Re: Riverwalk – *Technical Review 1*
PA23031

After reviewing the application materials for the above referenced proposal, the following technical review comments are provided below.

GRADING AND DRAINAGE PLAN

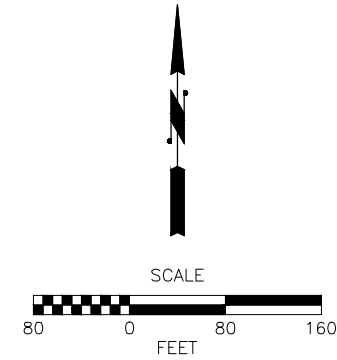
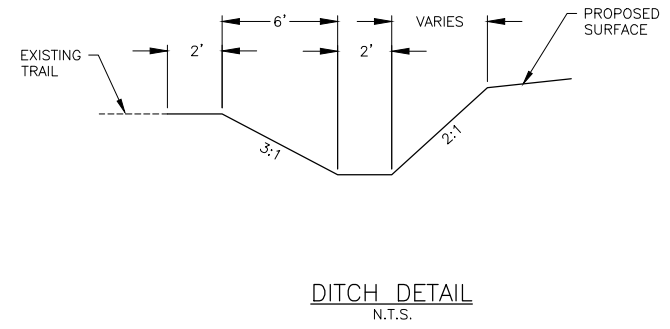
1. Provide file number PA23-031 on all future plan submittals.
2. The grading plans (E031) shall be amended so that **no** temporary stockpiling occurs on the lagoon fill pad (Stockpile A), as the PW Department utilizes this space for operational purposes. Until the PW Department has been relocated all stockpiling shall be placed on the Interfor property (60 State Avenue).
